MOD 2- Landscape responses

PROJECT Hammondcare Greenwich
PROJECT NO 19-165s
DATE 15.06.2026

The following are the Landscape Consultants responses to the RFI's raised by DPHI / Council's review of the Modification 2 submission with regards to additional information and clarification.

REV: E
DATE: 15.10.2025

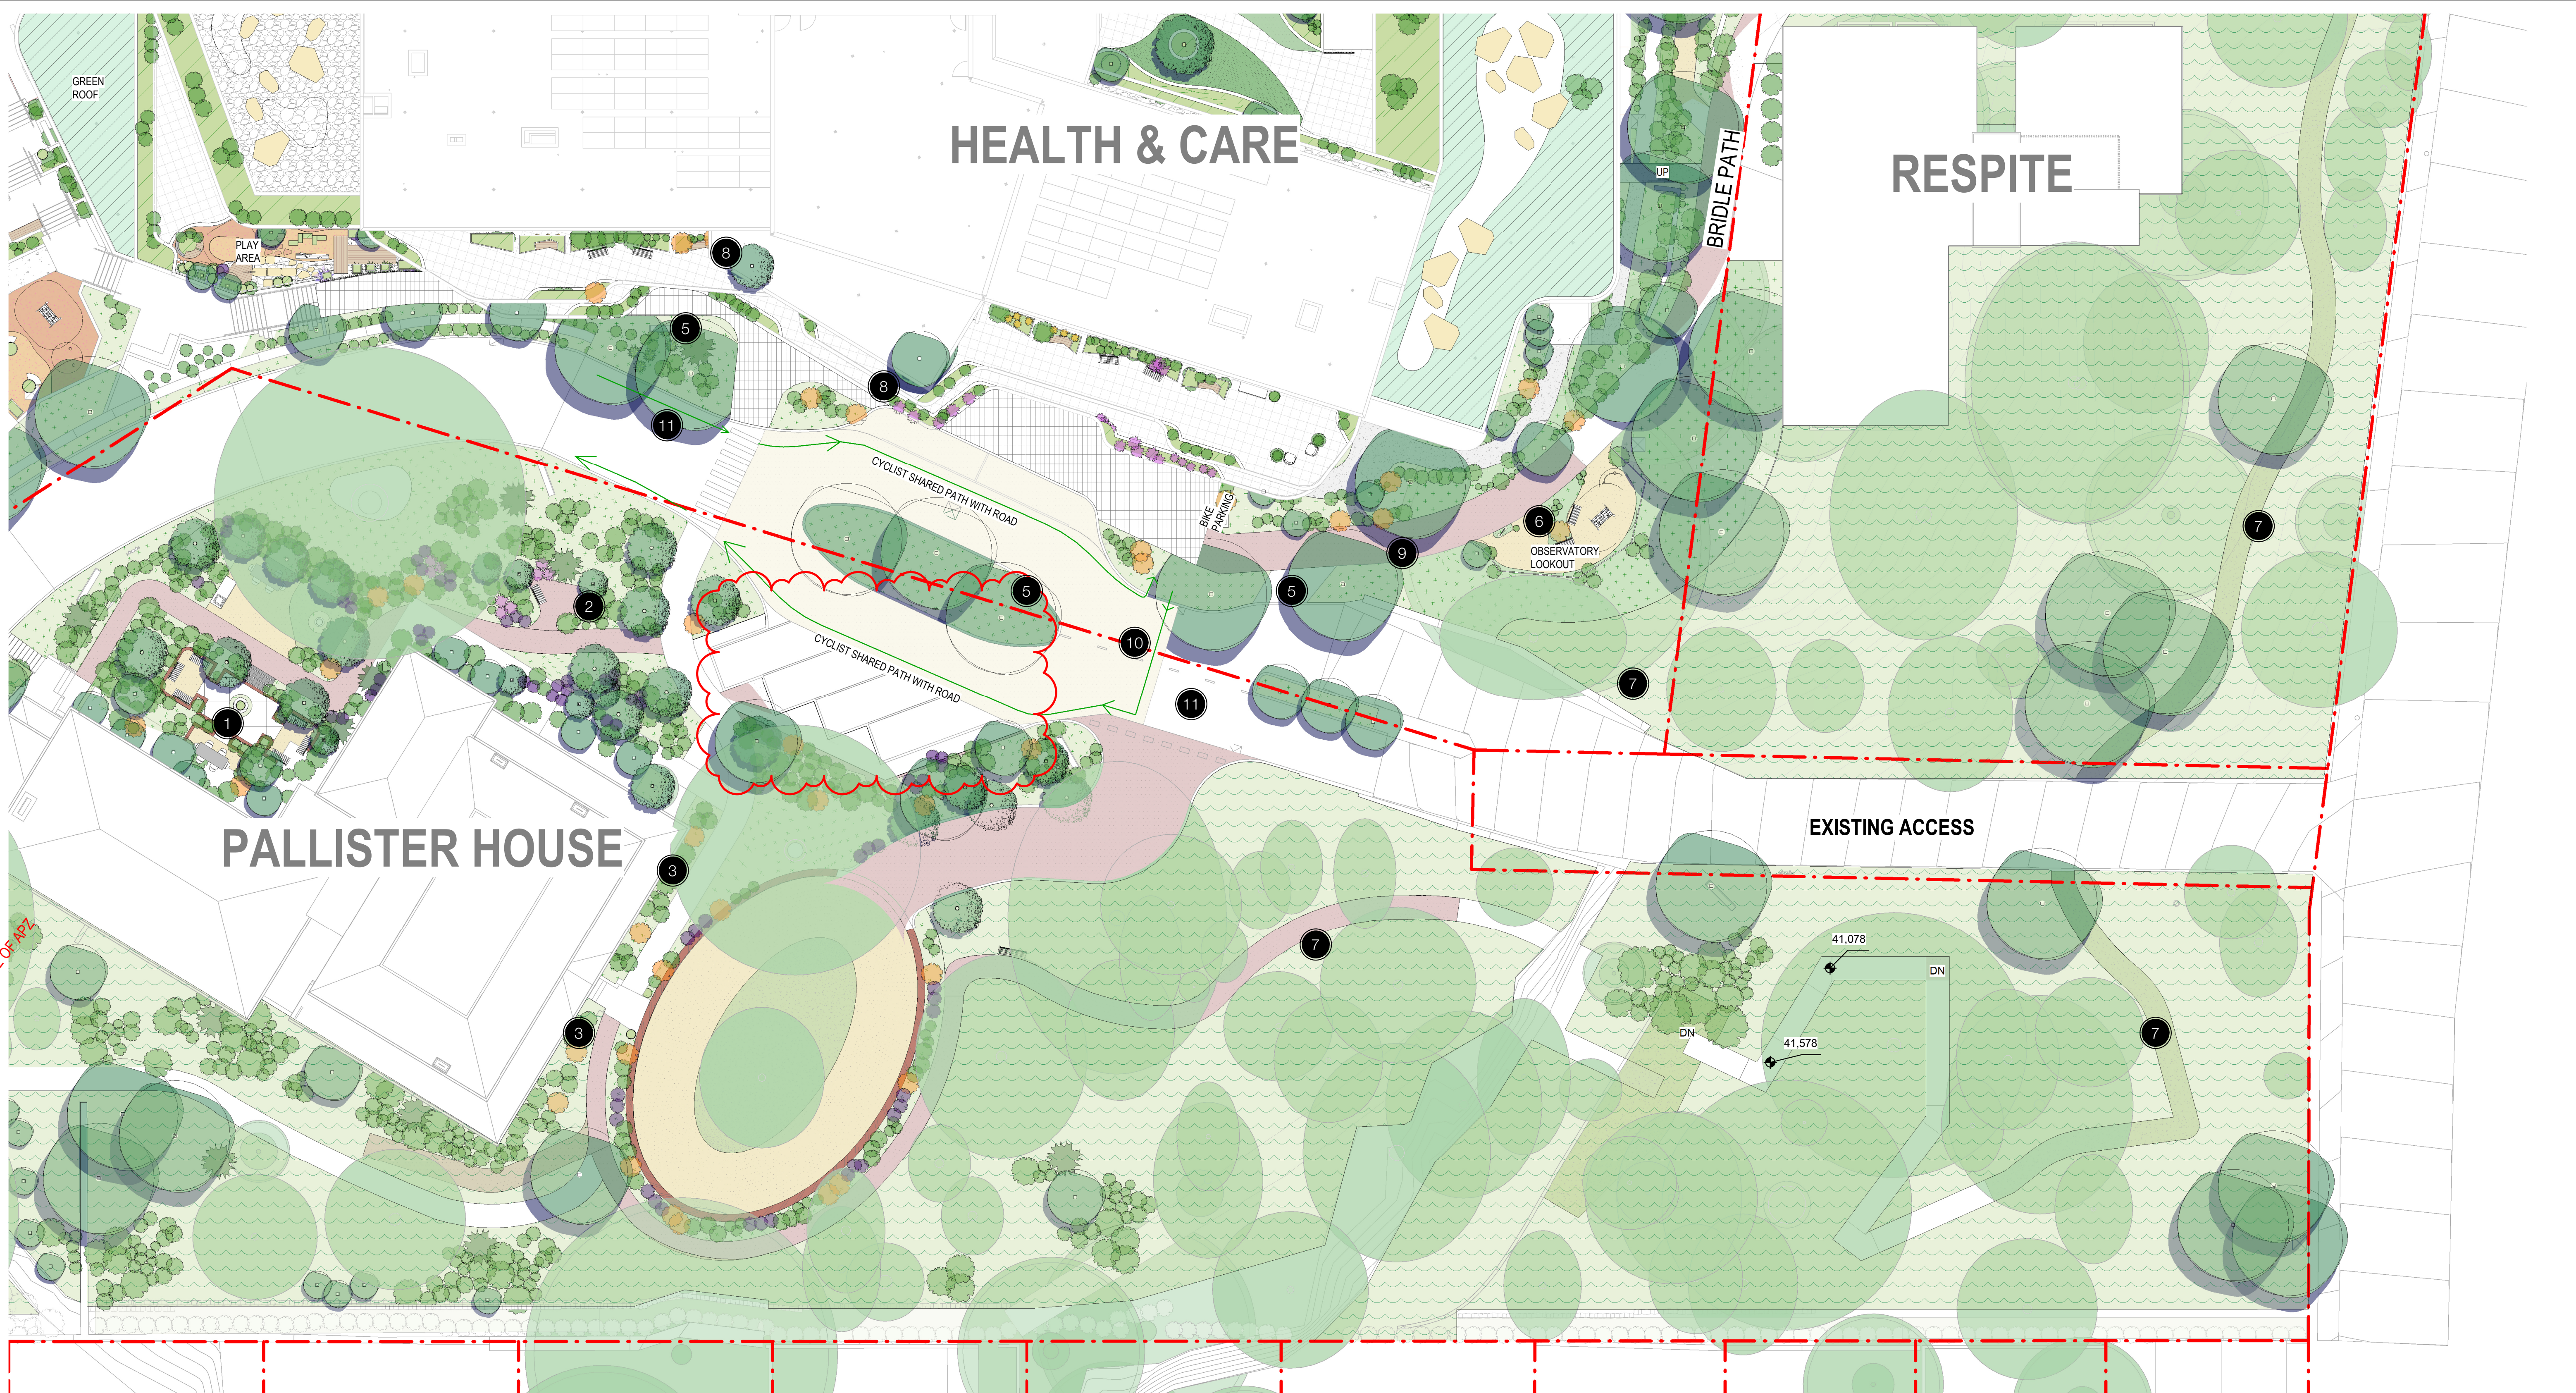
- a) The entry to the main carpark, which is accessed from the western entry road that comes off the western entry to the site from River Road, has been modified as directed by the traffic engineer. The turn into the parking area under the Senior's Living buildings, has been modified to accommodate the widened driveway and gentler radius turn in. The radius of the turn in, has been increased to improve sightlines for entering and exiting vehicles and of pedestrians crossing the path that runs Nth-Sth along the western edge of the building. The landscape at the driveway entrance, to the car park has been amended to accommodate and respond to this Clouded area in the NorthWest of drawing LA-101[F].

SENIOR LIVING LEVEL 3-4

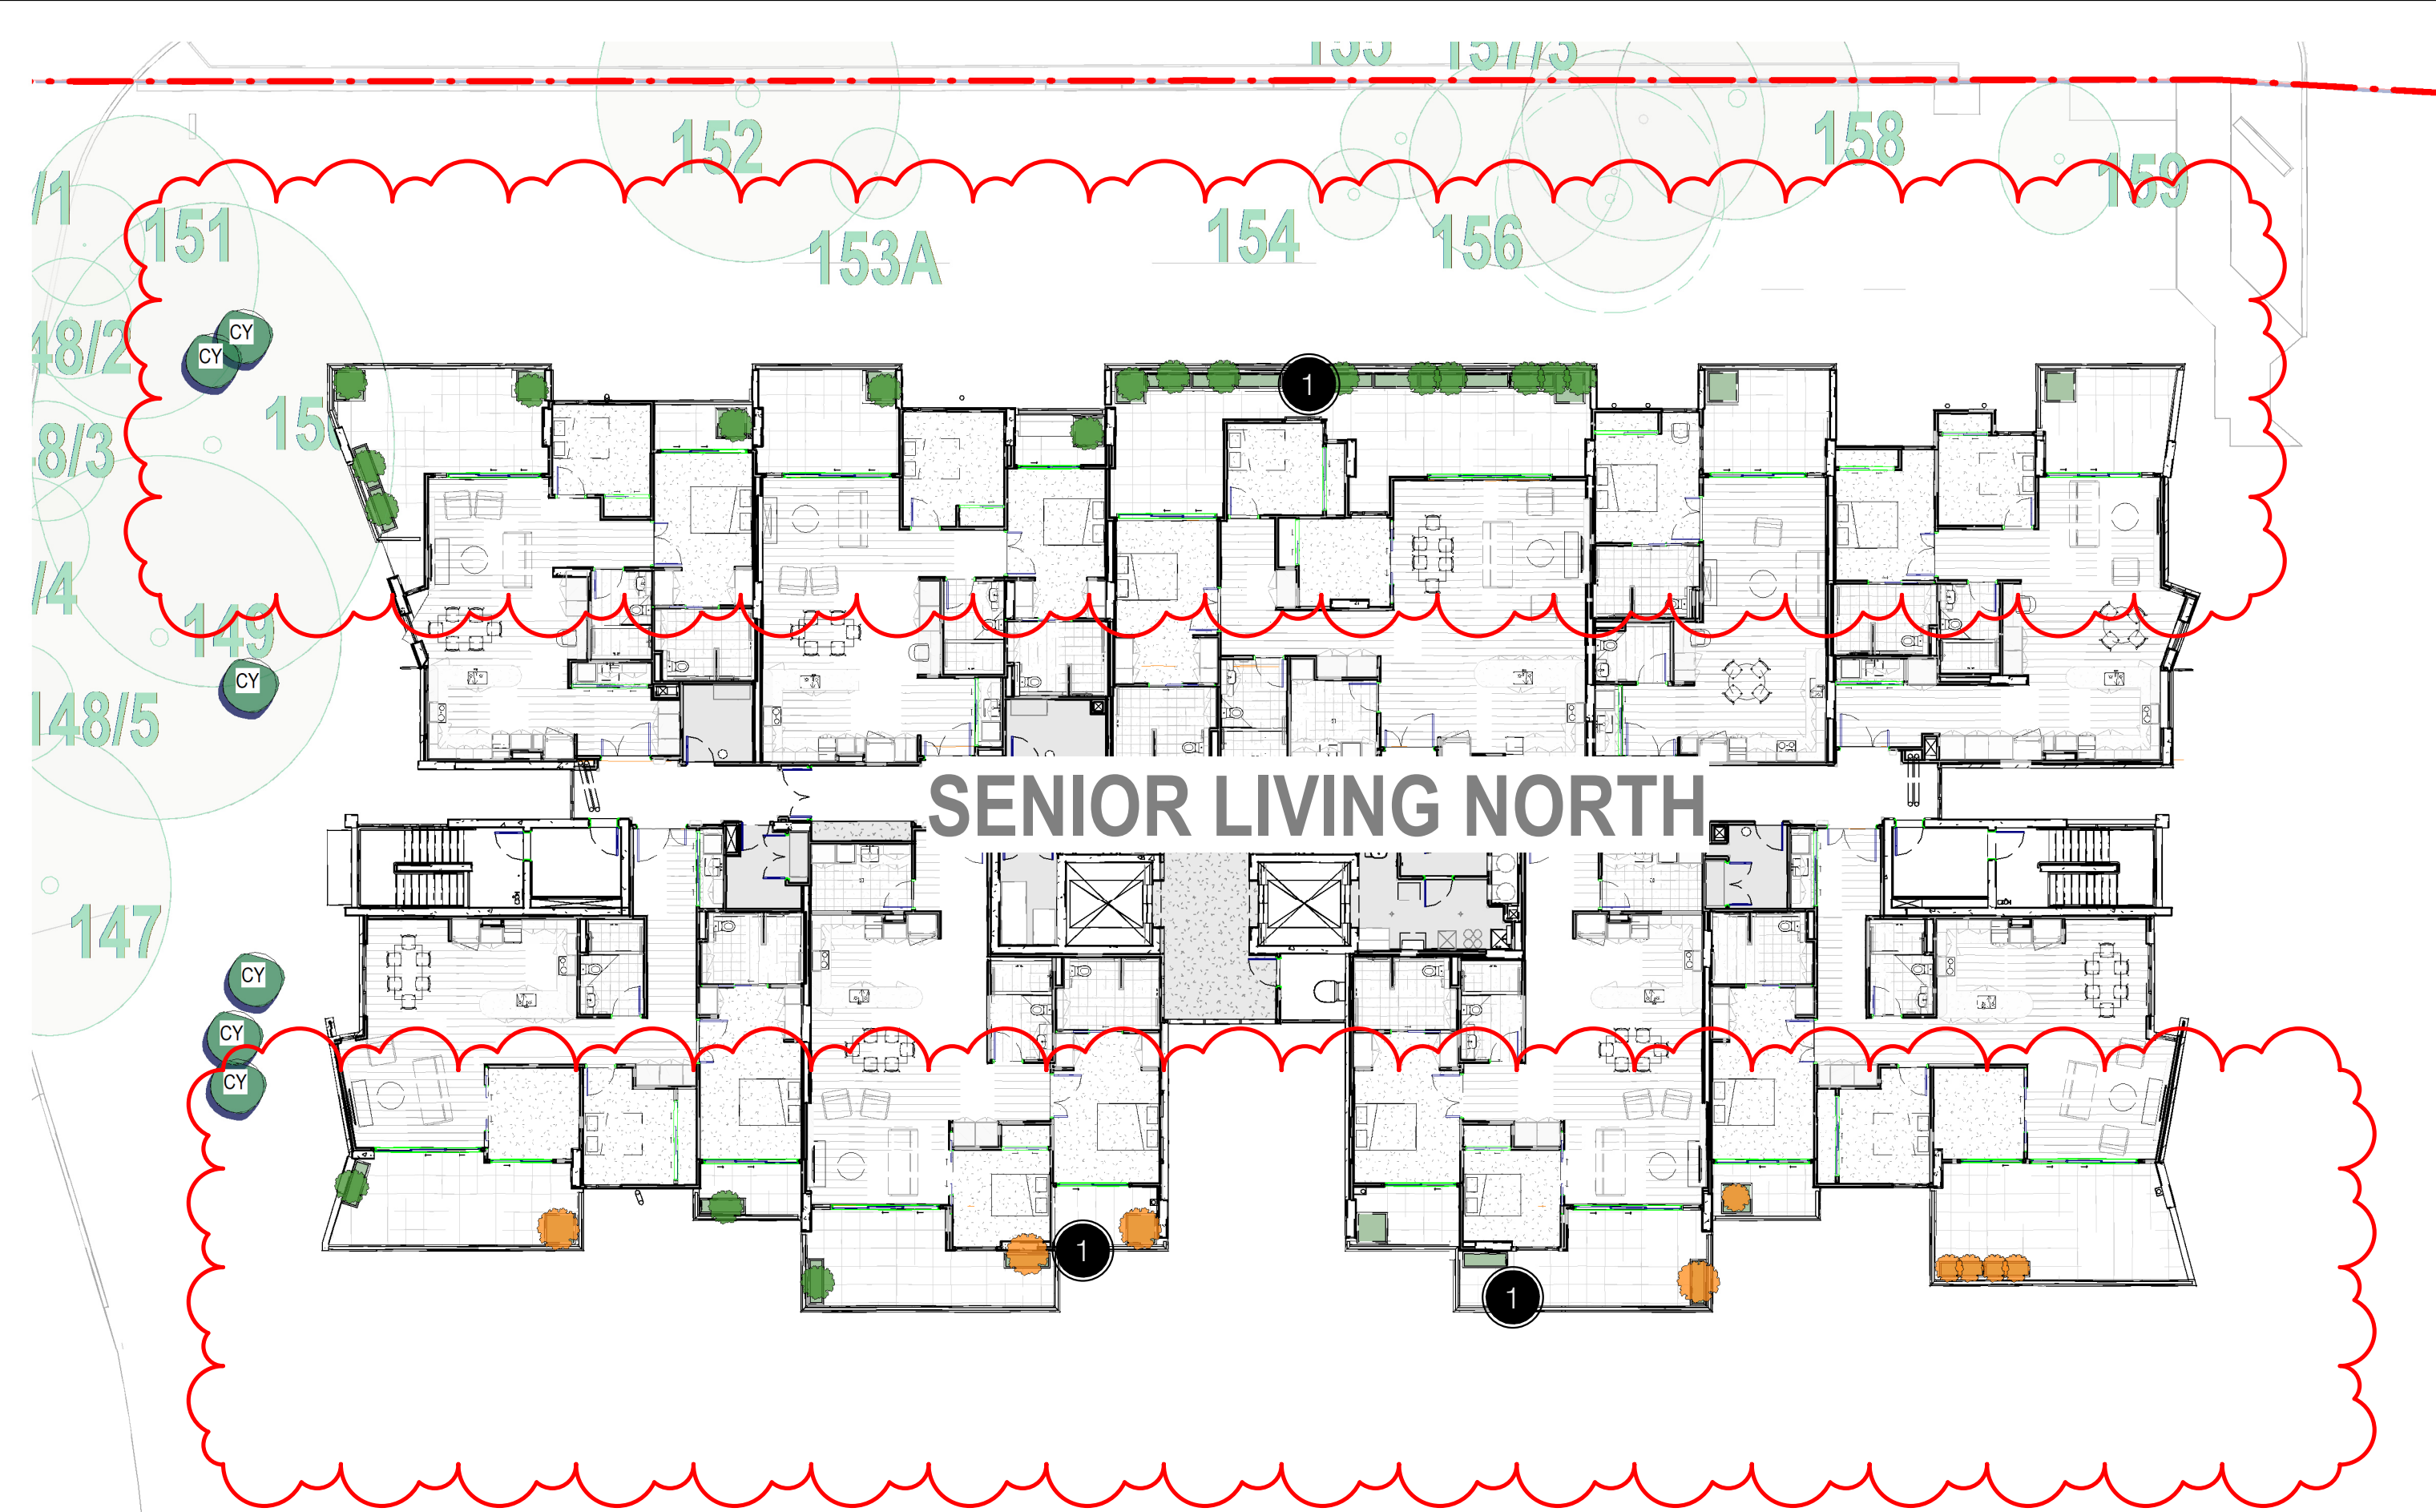
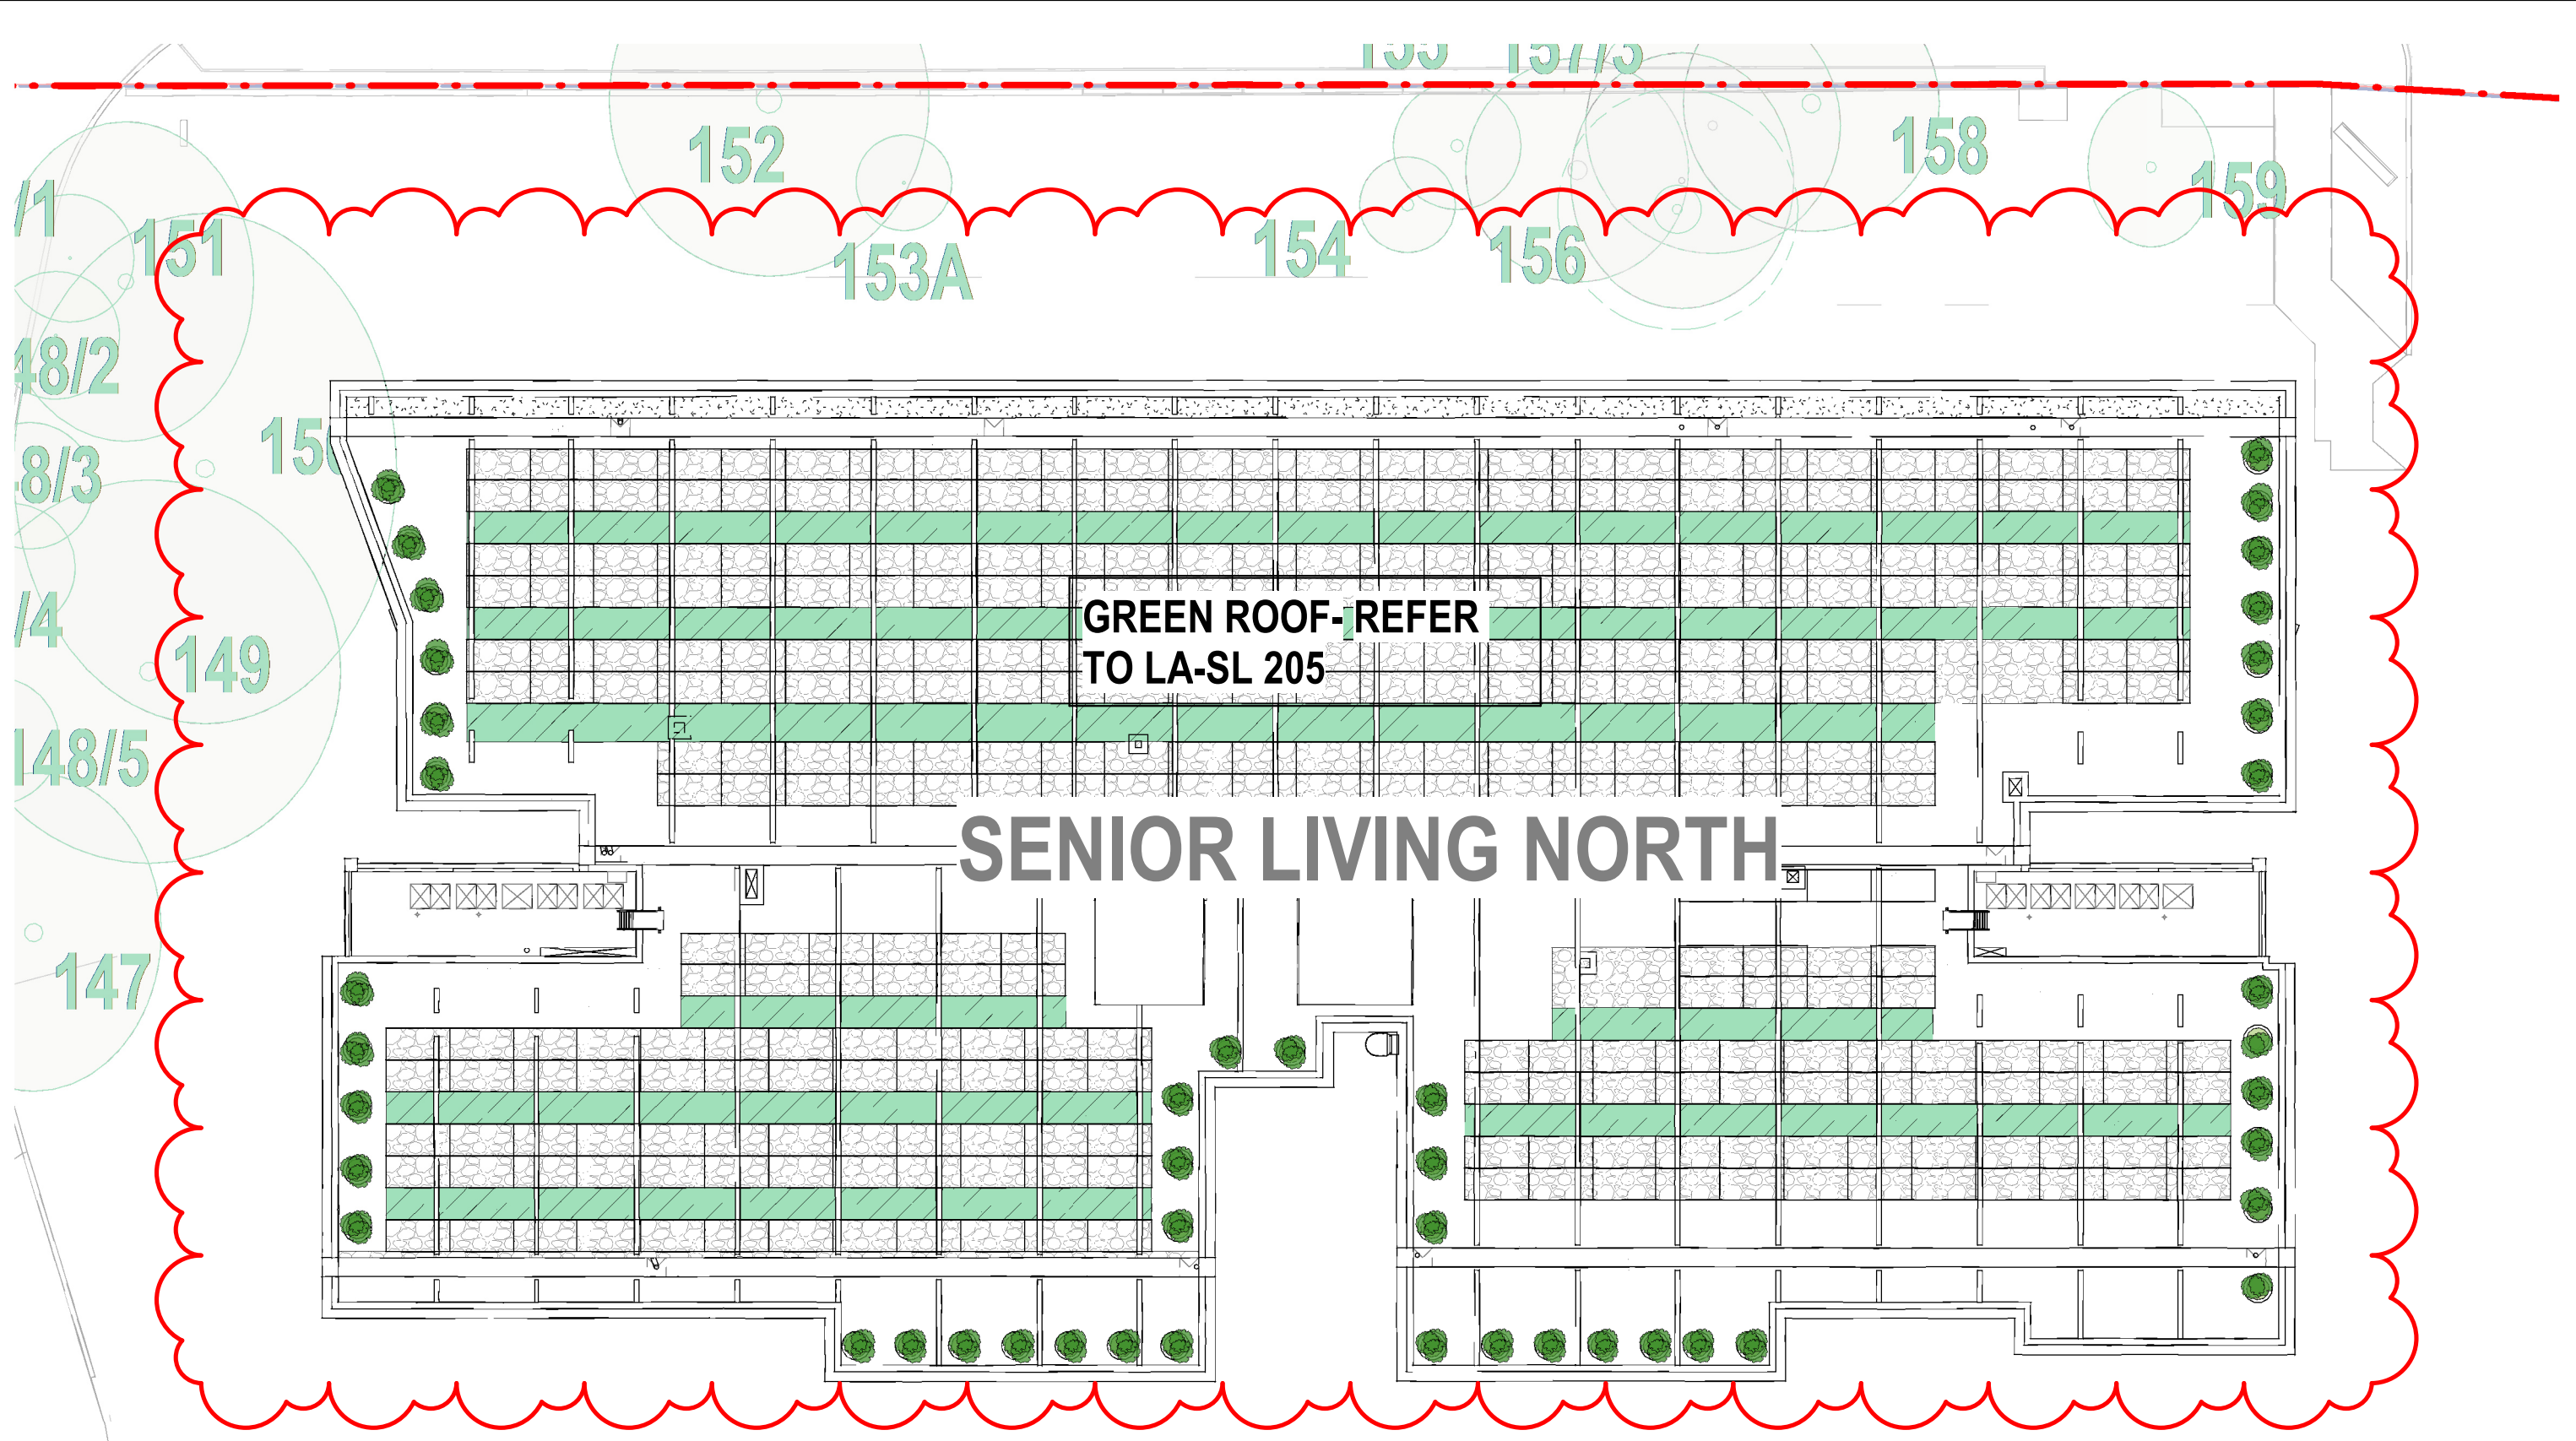
- b) The planters on the apartment terraces of the Seniors Living building's, have been substituted with GRC planter boxes. This change responds to issues identified during the Detail Design phase and takes into consideration buildability input, water proofing detailing and the construction program. Items resolved include waterproofing, drainage and appropriate separation between planter media and the slab. GRC planter sizes were selected based on size and market availability, with minor changes to the soil volume. (Refer to LA-SL-203 [E], LA-SL-204 [E]) We note that the south-western planter at the Seniors Living North building, closest to the adjoining residential properties, will remain as a raised planter that supports screening vegetation as is required by the SSDA. (Refer to LA-SL-203 [F], LA-SL-204 [F])

Planters that were isolated and maintenance access is difficult, have been removed. Privacy and screening issues between the Seniors living north and Seniors living south are unaffected as the distance between the terraces exceeds 15metres.
